# Consultee Comment for planning application 23/02098/OUT

<b>Application Number</b>	23/02098/OUT
<b>Location</b>	Begbroke Science Park Begbroke Hill Begbroke OX5 1PF
<b>Proposal</b>	<p>Outline application, with all matters reserved, for a multi-phased (severable), comprehensive residential-led mixed use development comprising: Up to 215,000 square metres gross external area of residential floorspace (or c.1,800 homes which depending on the housing mix could result in a higher or lower number of housing units) within Use Class C3/C4 and large houses of multiple occupation (Sui Generis); Supporting social infrastructure including secondary school/primary school(s) (Use Class F1); health, indoor sport and recreation, emergency and nursery facilities (Class E(d)-(f)). Supporting retail, leisure and community uses, including retail (Class E(a)), cafes and restaurants (Class E(b)), commercial and professional services (Class E(c)), a hotel (Use Class C1), local community uses (Class F2), and other local centre uses within a Sui Generis use including public houses, bars and drinking establishments (including with expanded food provision), hot food takeaways, venues for live music perform

Figure 2.25 – Areas of sensitive receptors

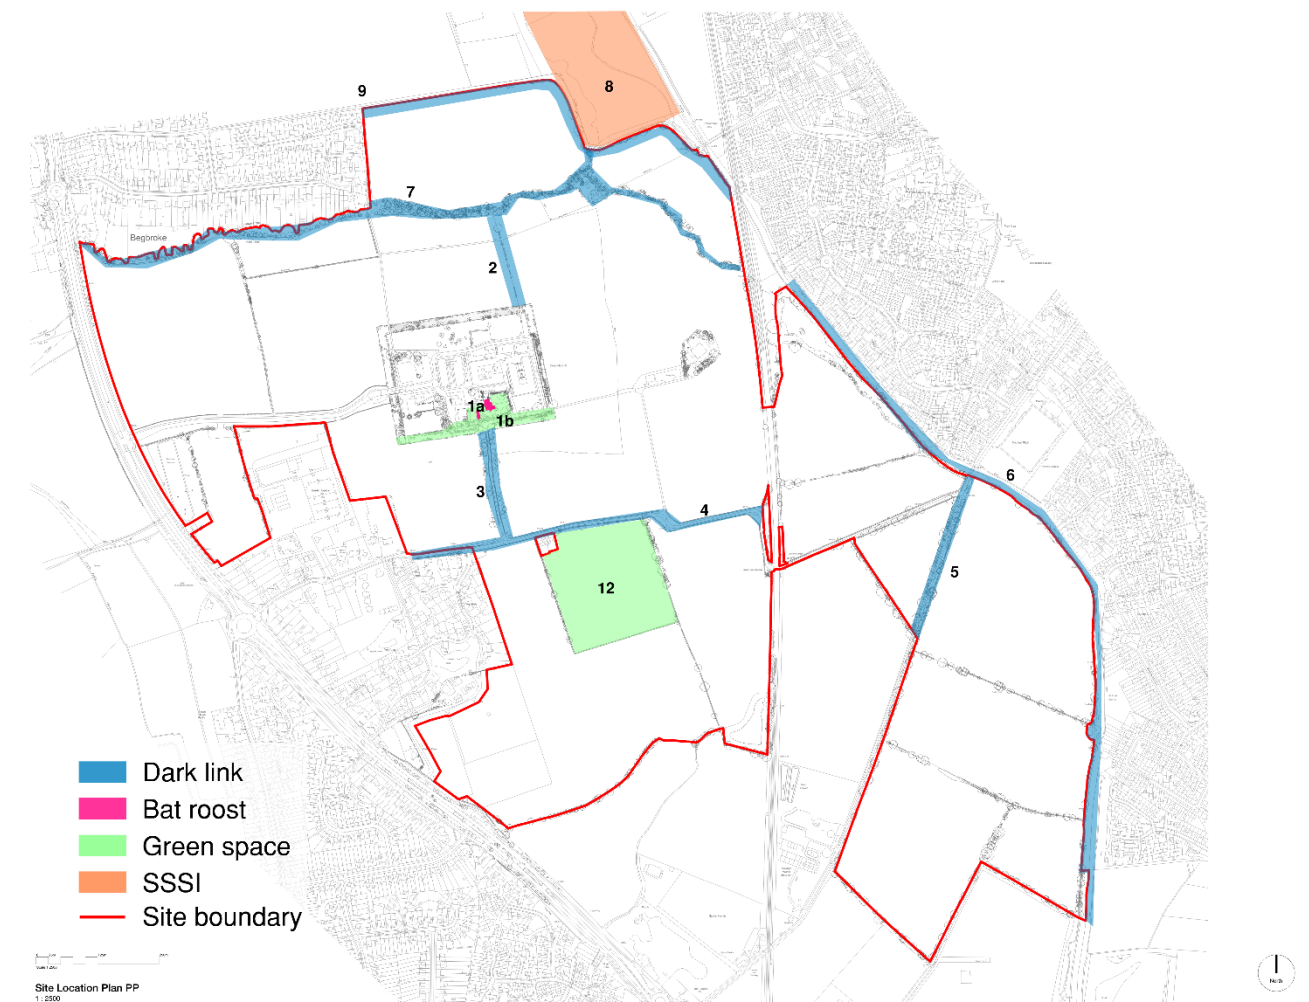
The Framework Lighting Strategy (Buro Happold, July 2023) includes dark corridors for bats and wildlife. However, it should be noted that the report references an old BCT guidance note. The final lighting strategy should incorporate the BCT new guidance note (Guidance note 08/23) as well as the updates listed in the Environmental Statement Addendum (November 2023, Quod). I also have some concern over the lighting of the path in the northeast corner. The path is proposed to be lit at 2.0 lux, but BCT guidance recommends that illuminance is reduced to <0.5 lux within dark corridors and on key & supporting features or habitats. The provision of an updated lighting strategy at the reserved matters stage, including submission of contour plans illustrating Lux levels, should be conditioned.
